# One Earth Solar Farm

**Draft Statement of Common Ground with West Lindsey District Council**

**EN010159/APP/8.4.43**

**November-December 2025**

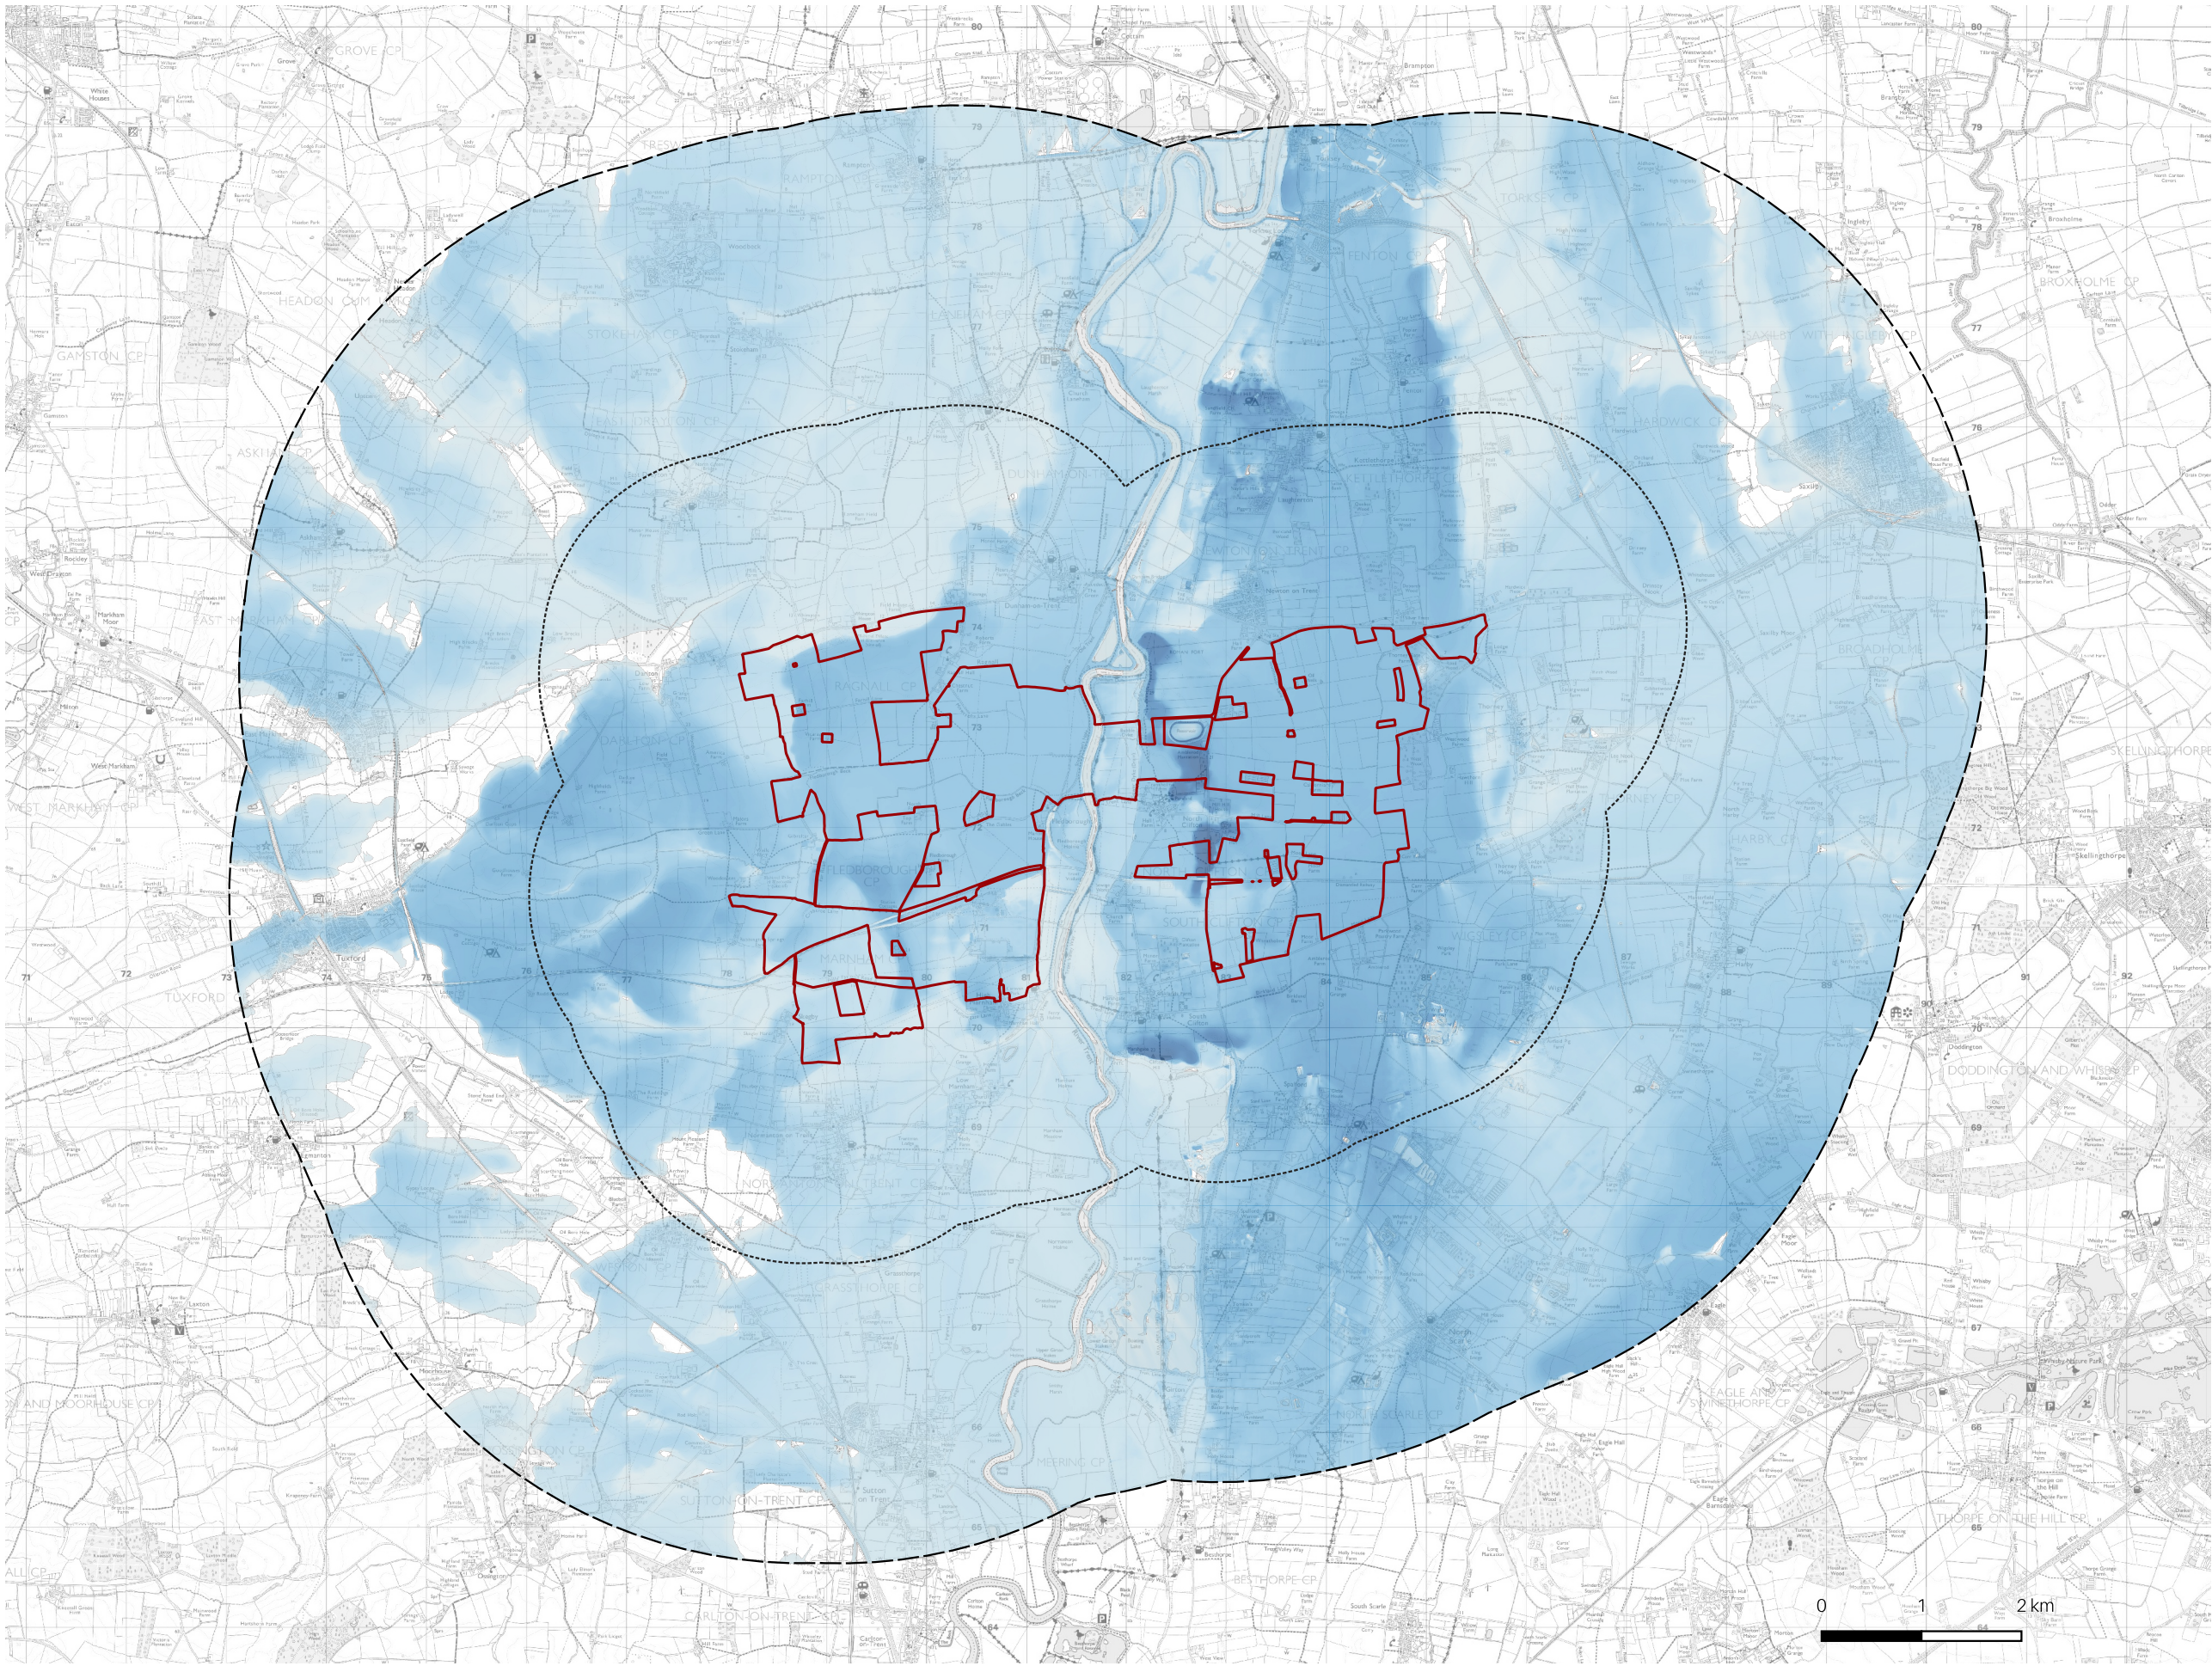
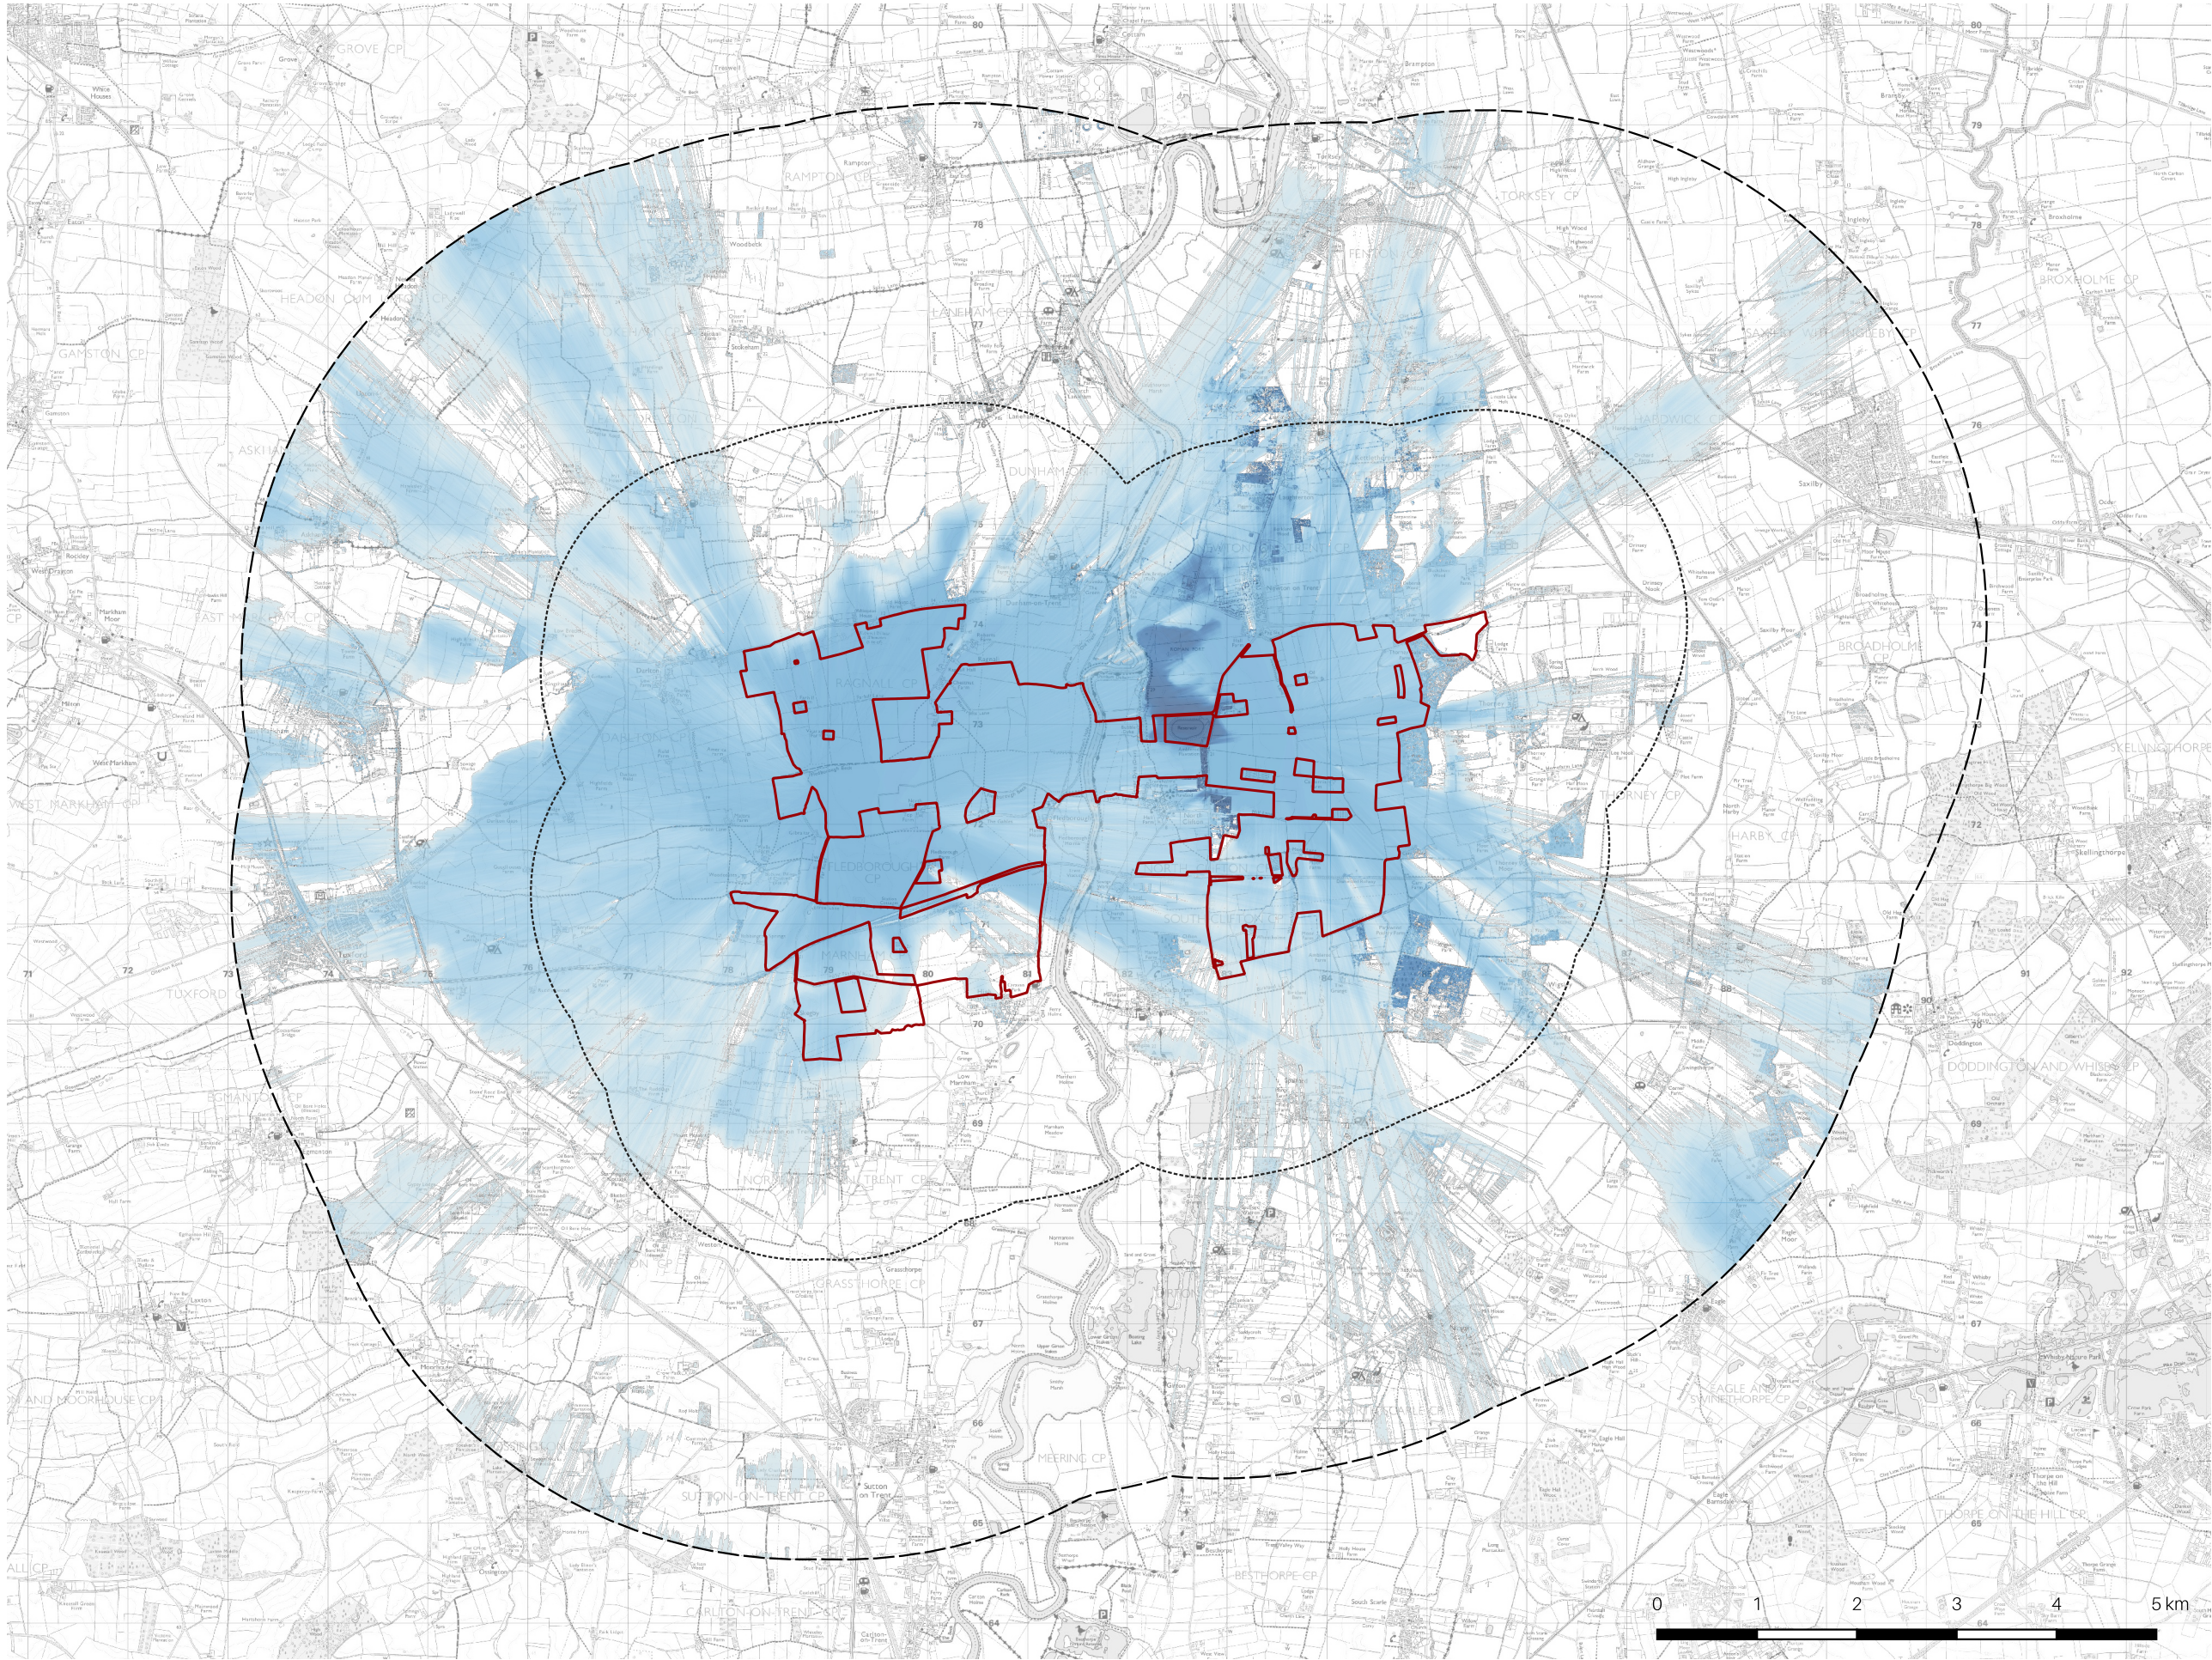
04-03	Scope of landscape receptors	No comments or concerns on the scope of landscape receptors have been raised to date.	The scope of landscape receptors is agreed.	Agreed
04-04	Scope of visual receptors	No comments or concerns on the scope of visual receptors have been raised to date.	The scope of visual receptors is agreed.	Agreed
04-05	Scope of representative viewpoints	<p>West Lindsey District Council would request that a representative viewpoint is included from the layby on the A1133 (53°14'36.0"N 0°45'37.5"W) (What3Words Monkeys.stunner.newlywed). We agree this will be supplementary to the existing assessment <del>but await further information being supplied.</del></p> <p><u>WLDC welcome the production of a verified view which was tabled at a meeting regarding this SoCG.</u></p> <p><u>WLDC consider that this verified view should be submitted into examination as it provides a helpful context to understanding the potential visual impacts associated with each of the two substation options the applicant has</u></p>	<p>The Applicant has provided a baseline photograph from the suggested location at Deadline 5.</p> <p>This was agreed to be supplementary to the existing assessment of motorists along the A1133, rather than requiring further assessment.</p> <p><u>The locations and number of viewpoints was agreed during the pre-application process. Subsequently an additional viewpoint photograph was requested from the A1133 which has now been provided.</u></p> <p><u>No response for an additional photomontage was received from WLDC until 01/12/2025. The</u></p>	Under Discussion <del>Not Agreed</del>

<p><u>identified. In particular the verified view demonstrates the horizon line below which the proposed substation would be less visible from the A1133.</u></p> <p><u>We note however that this verified view does not provide a visualisation of the proposed development which would assist the Examining Authority in understanding the proposals in context.</u></p>	<p><u>photomontage showing the proposed development from viewpoint 4 [REP2-031] was prepared to show views from the A1133 and therefore representative of people driving along this route.</u></p>	
04-06	Scope of photomontages	<p>West Lindsey District Council suggested an additional Type 4 photomontage from Viewpoint 8 along the A57 following review of the PEIR.</p> <p>No further comments or concerns on the scope of representative viewpoints have been raised to date.</p>	<p>Further discussion was had between the applicant and the District Councils during the preparation of the LVIA ES Chapter regarding the scope of photomontages resulting in agreement that any justification for the photomontage scope should be included within the LVIA.</p> <p>The photomontage scope is agreed.</p>	Agreed
